DRB Application No.: **07DRB-70369**

Project Name: **PEREA ADDITION**

RE: Perea Addition Lots/minor plat

**PLAT OF  
 TRACT A  
 LANDS OF CIBOLA ENERGY CORPORATION  
 AND  
 LOTS 19-A AND 20-A, BLOCK 17  
 PEREA ADDITION**

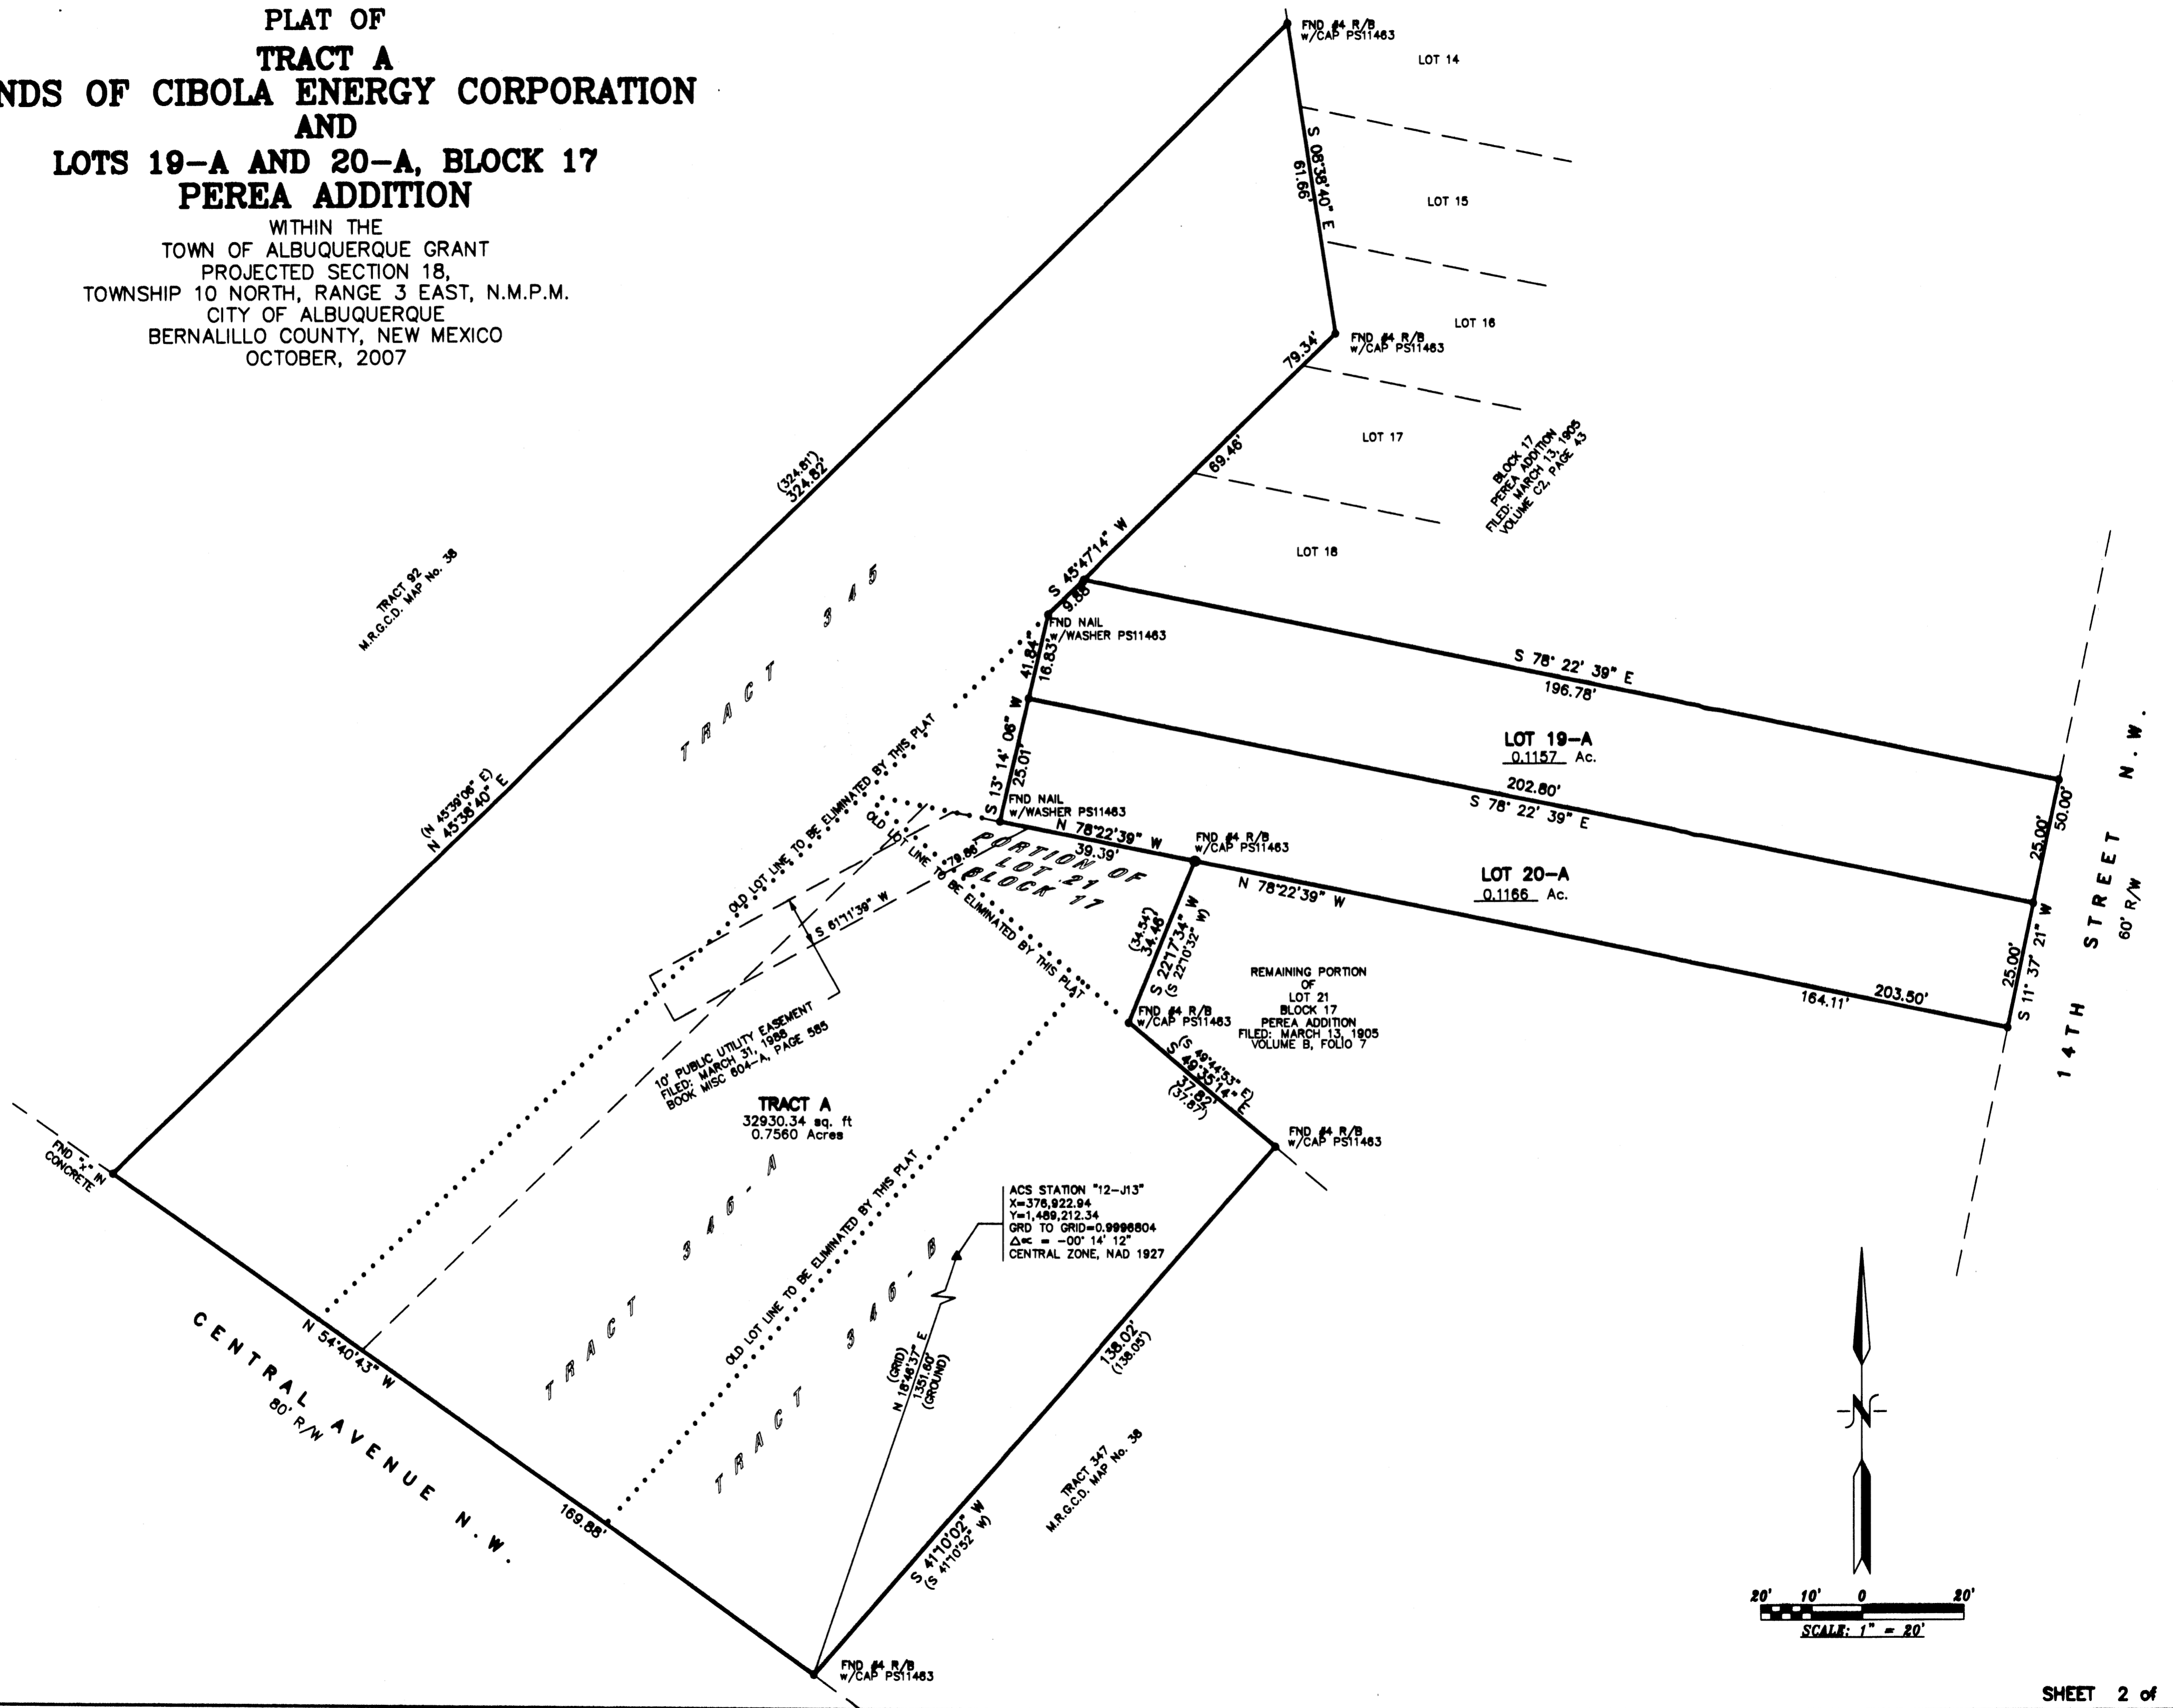
TRANSPORTATION: 10' face of curb to property line
dedicate 6 feet of right of way bike lane.
recording info on draw plat along Central

PLANNING (Last to sign): AGIS dxg
change zoning to S22/cc
record the plat

JACKS HIGH COUNTRY INC agent(s) for CIBOLA ENERGY CORPORATION request(s) the above action(s) for all or a portion of Lot(s) 19, 20M AND PORTION OF LOT 21, Block(s) 17, Tract(s) 345, 346 - A, **PEREA ADDITION**, zoned SU2, located on WEST CENTRAL AVE NW BETWEEN 14TH NW AND 15TH NW containing approximately 0.99 acre(s). (J-13) **THE PRELIMINARY PLAT WAS APPROVED WITH FINAL SIGN OFF DELEGATED TO PLANNING FOR AGIS DXF, CHANGE ZONING TO SU2-CC, AND TO RECORD AND TO TRANSPORTATION FOR 10 FT FACE OF CURB TO PROPERTY LINE DEDICATION, 6 FT OF RIGHT-OF-WAY FOR BIKE LANE AND RECORDING INFORMATION ON DRIVE PAD ALONG CENTRAL.**

The zoning is SU2-CC. We will also take delegation until the zoning on the plat is correct.
